Unit 13 and 14 Shaw Park Silver Street Response to Environmental Health 02.03.26

**Title**  
Figure 2 - Proposed Layout and Location of Exhausts

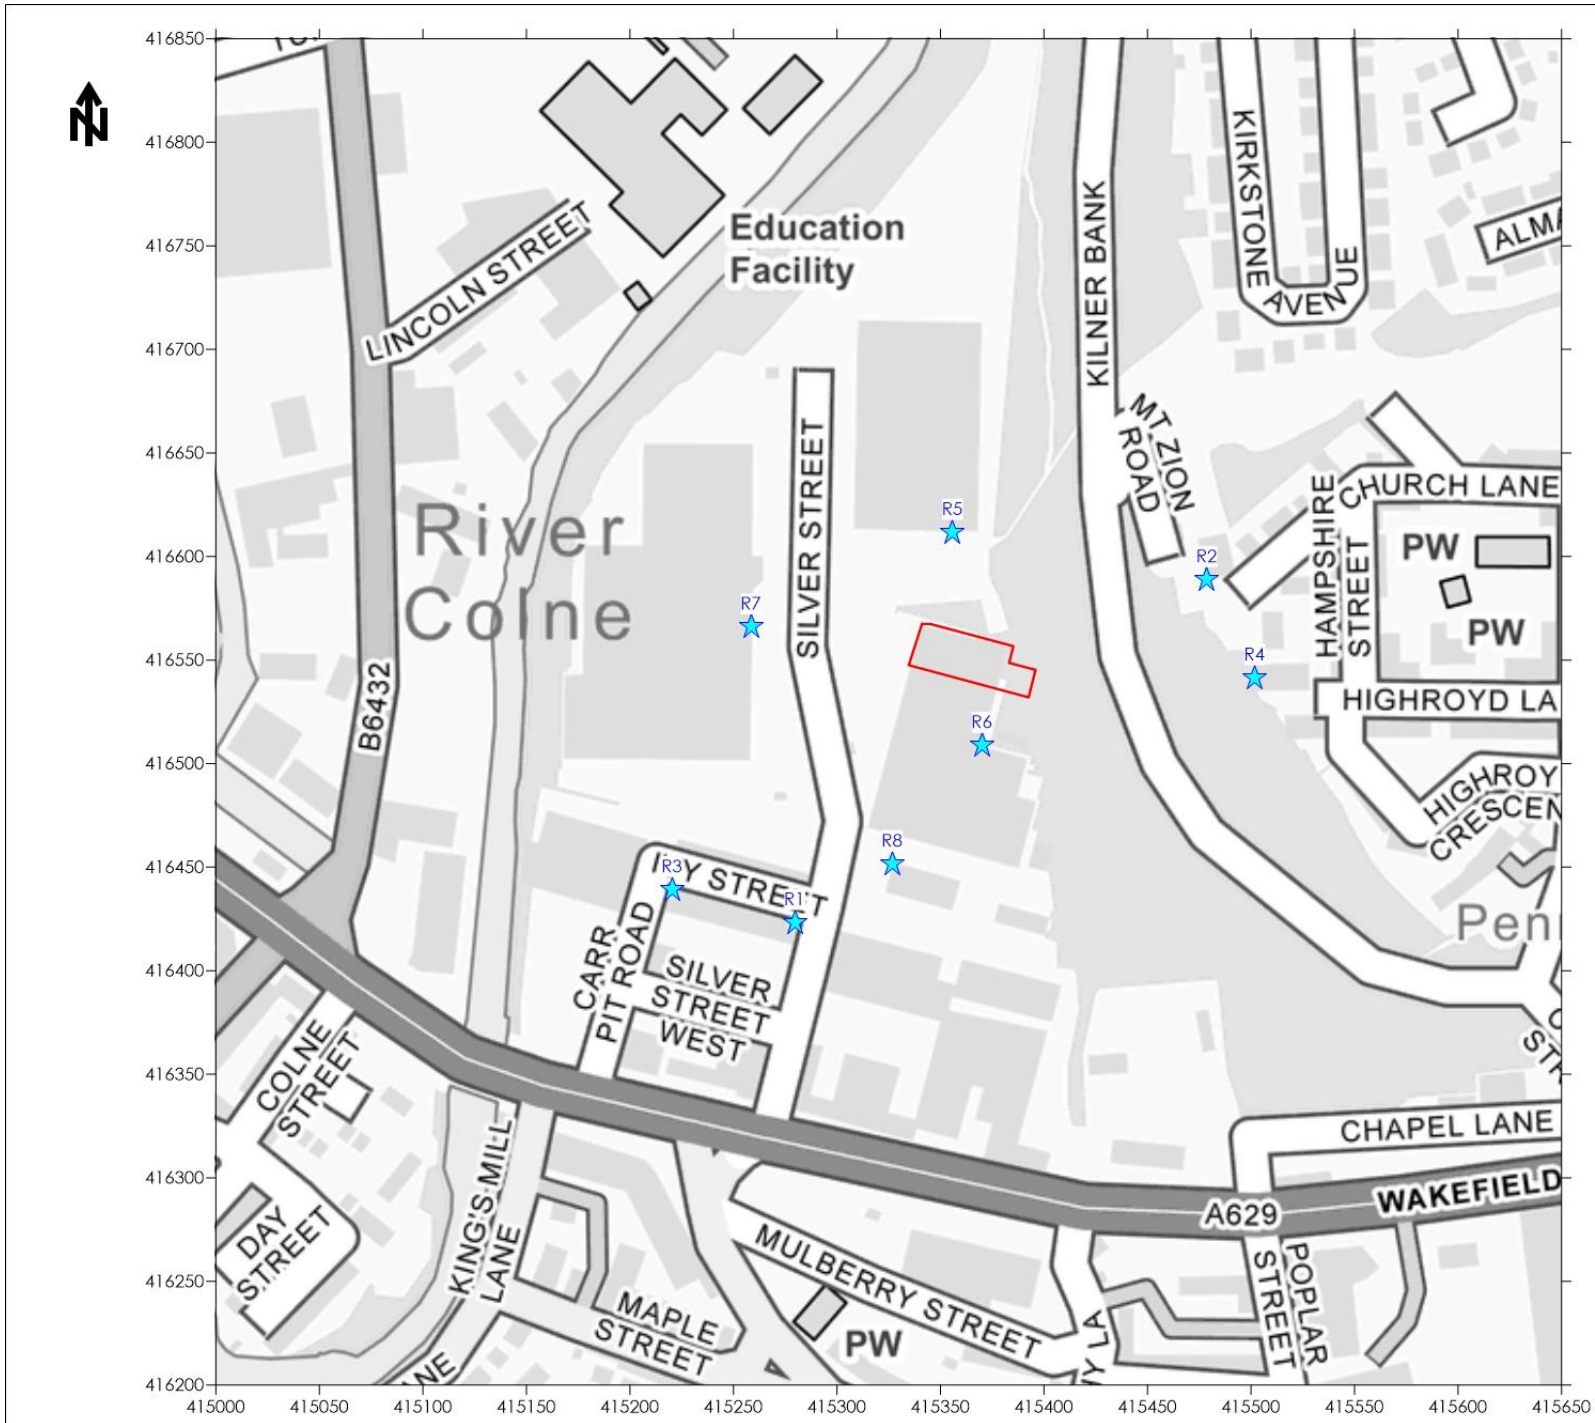
The proposed spraybooth extraction ducts have been designed with a discharge stack terminating 3m above the roof apex. The initial stack height has been specified in accordance with industry best practice for dispersion and in alignment with the requirements of the Environmental Protection Act 1990.

In accordance with statutory guidance, we can undertake a detailed D1 dispersion assessment to determine whether a reduction in the proposed stack height would be acceptable. The purpose of this assessment would be to quantitatively demonstrate that emissions achieve adequate atmospheric dispersion, potentially addressing the Council's requirement for separate odour and noise survey submissions where risk can be demonstrated to be negligible.

In addition, exhaust air will be discharged vertically at a minimum efflux velocity of 15 m/s. This is consistent with recognised dispersion best practice and ensures effective plume rise and atmospheric dilution. The combination of vertical discharge, appropriate efflux velocity, and stack positioning above roof apex level is specifically intended to minimise downwash, prevent localised recirculation, and safeguard nearby receptors.
